I object to the development project SSD 9679 “Hills of Gold Wind Farm” consisting of 70 wind turbines in the Nundle and Hanging Rock district of Northern New South Wales.

I propose a number of questions and tasks for the proponent that require a response:

Figure E1a Preliminary Assessment Tool: NAD\_1

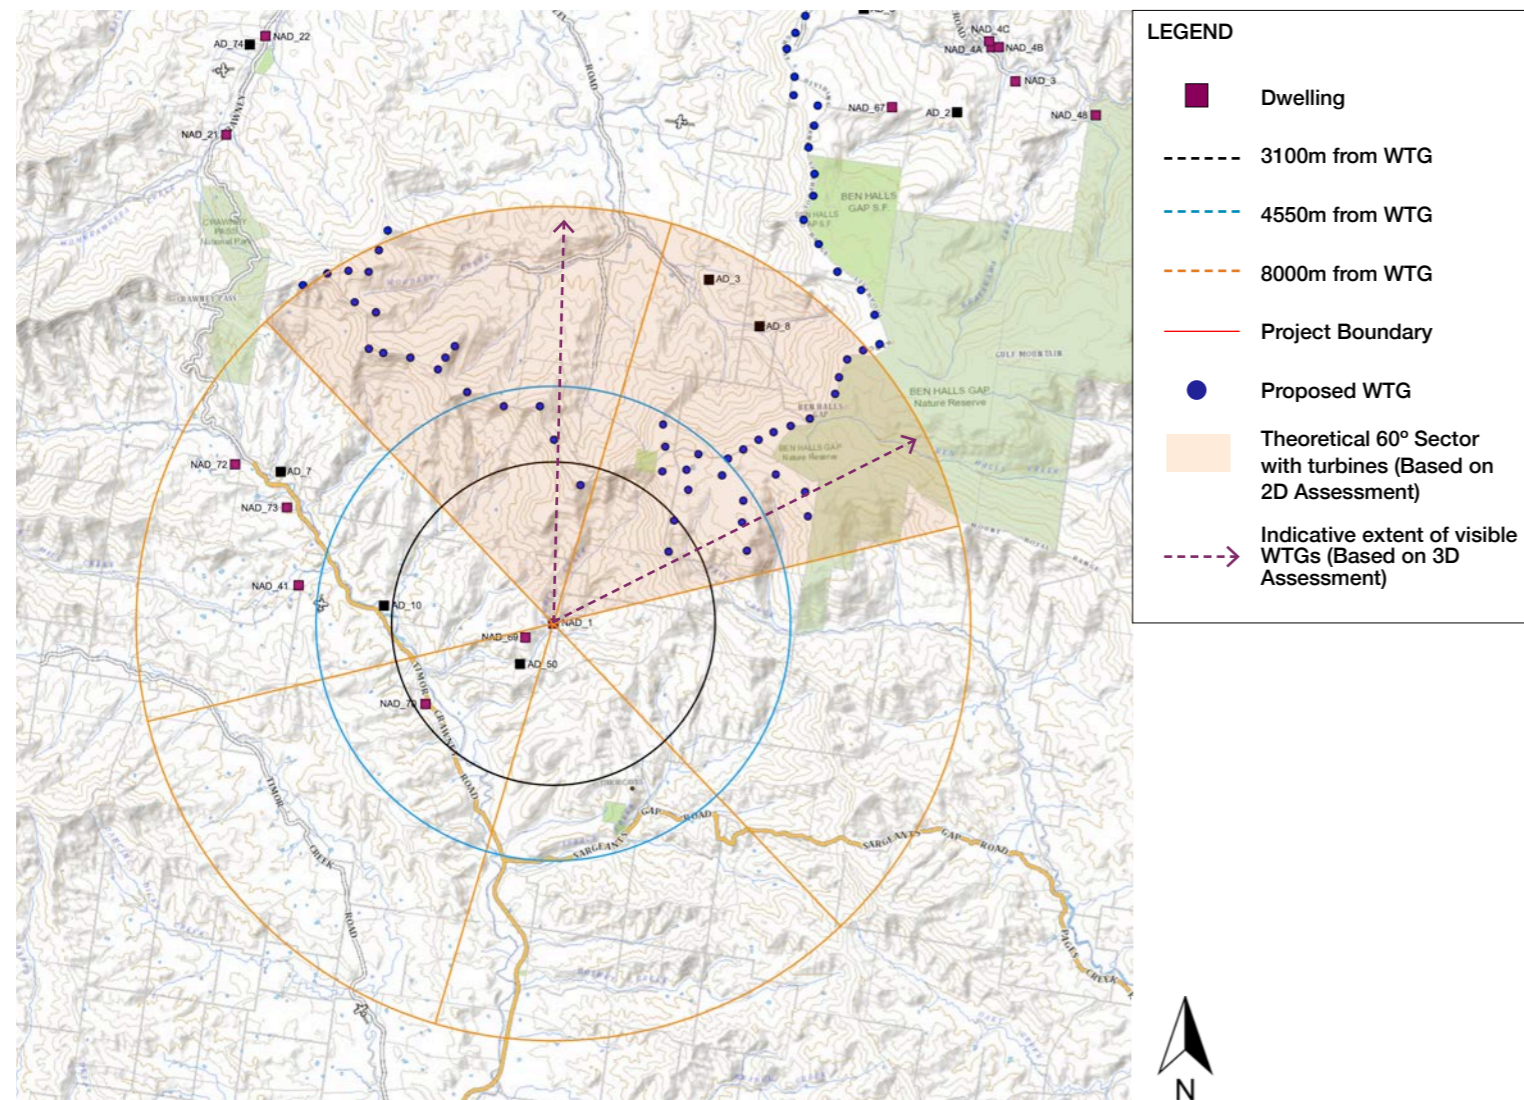
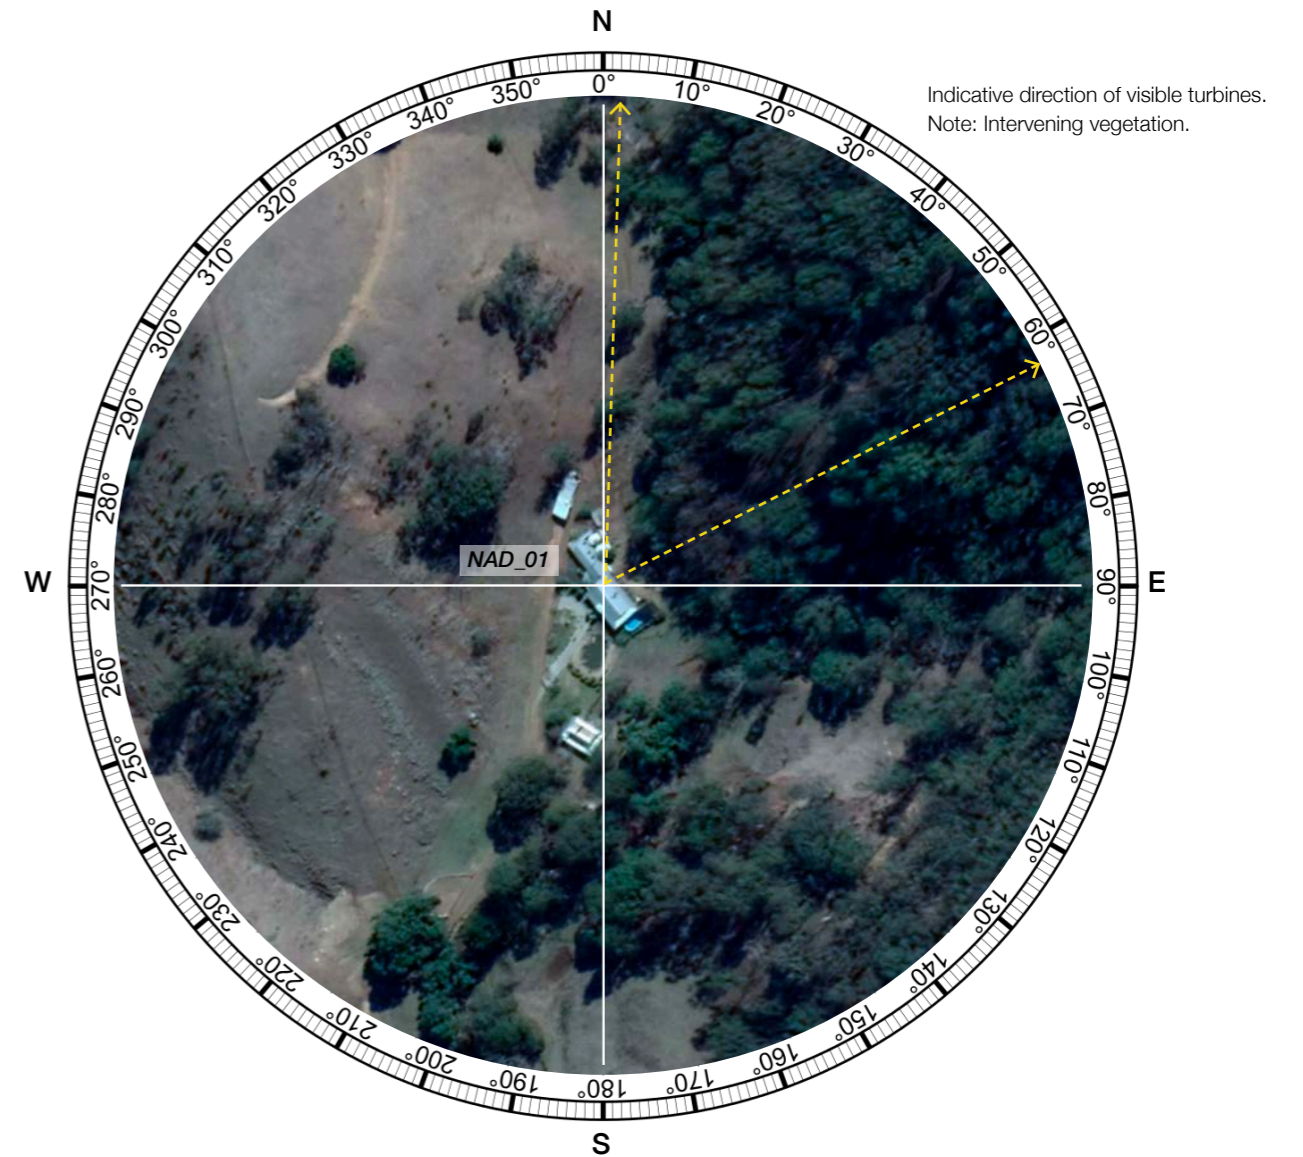
22: What has been the level of consultation with property NAD1?

23: Visual effects rating based upon desktop assessment "low" for NAD1, please conduct photomontage to verify?

Figure E22a Preliminary Assessment Tool: NAD\_69

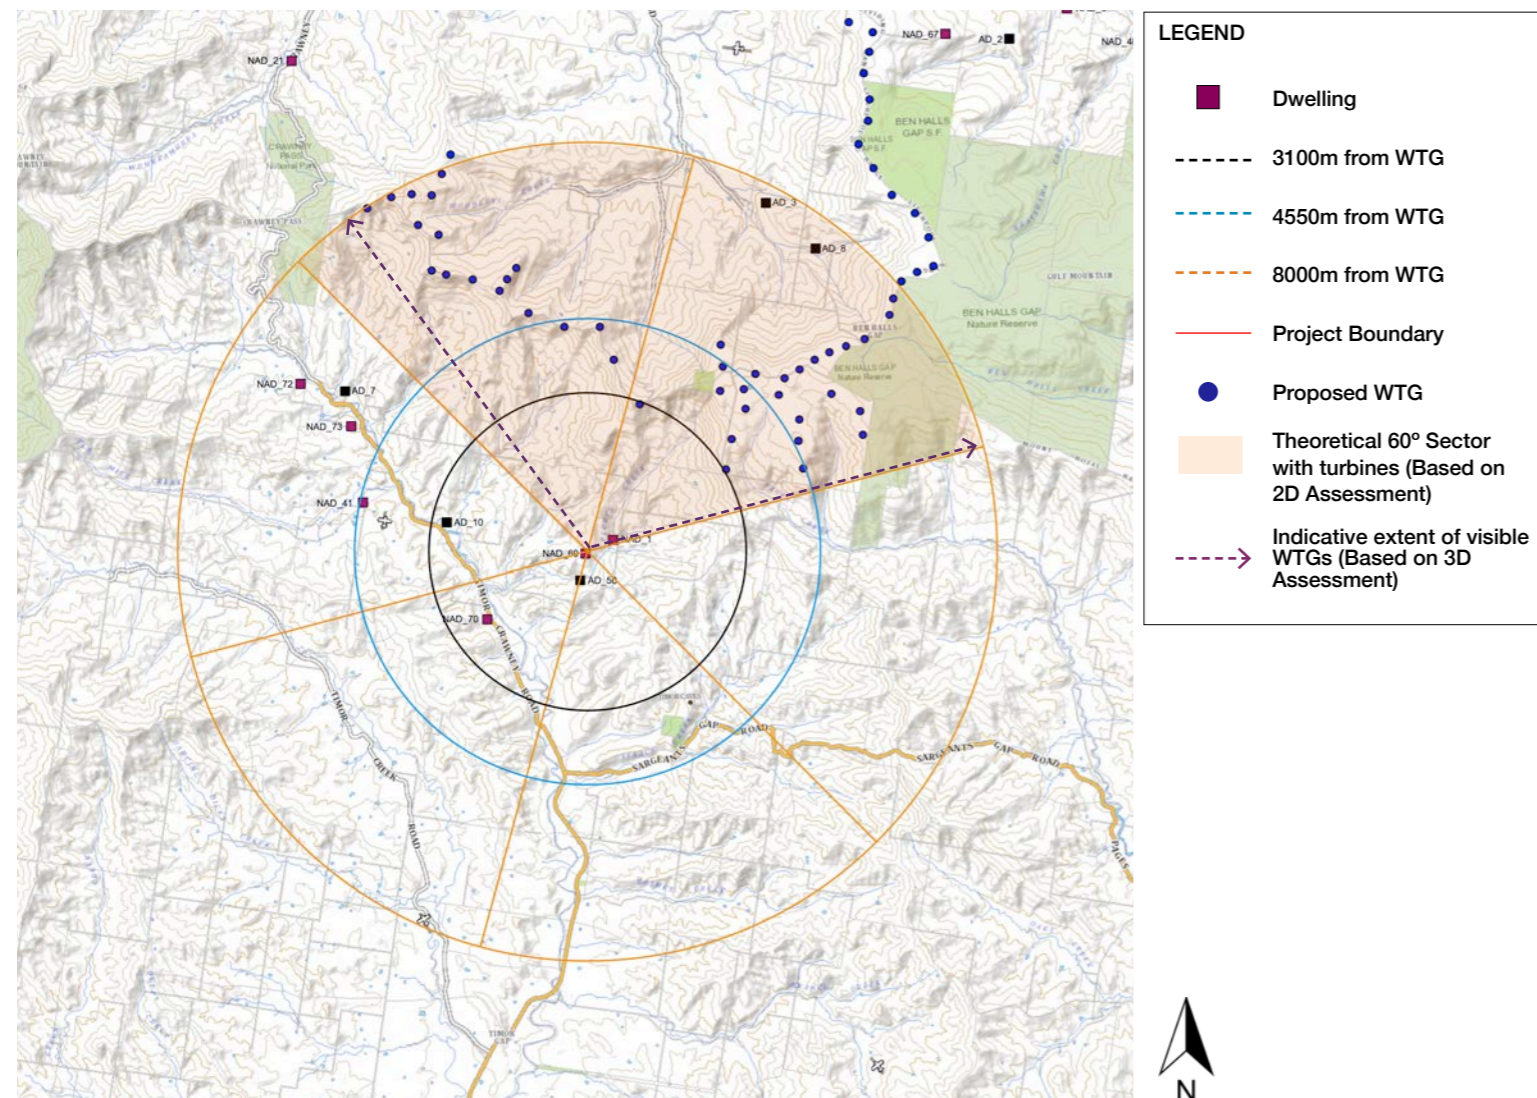
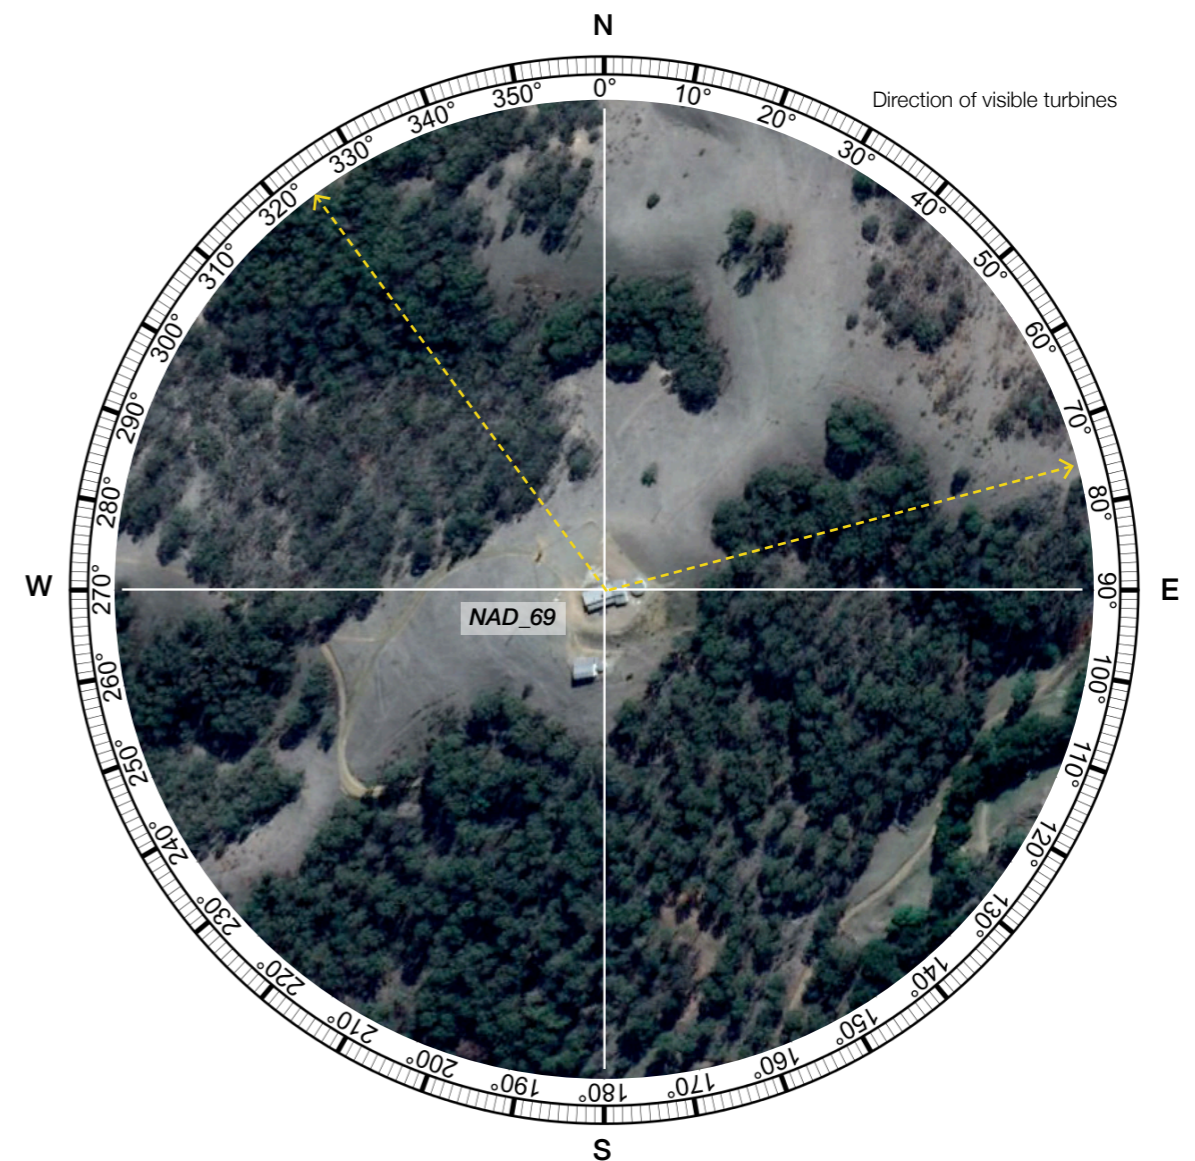
Positioned on the Southern end of the Crawney turbine placement design, the immediate turbine removal is required based upon distance to 2 non-associated residences NAD 01 and NAD 69. The 2 non-associated properties have had little or no consultation with 1 dwelling having desktop analysis for visual assessment.
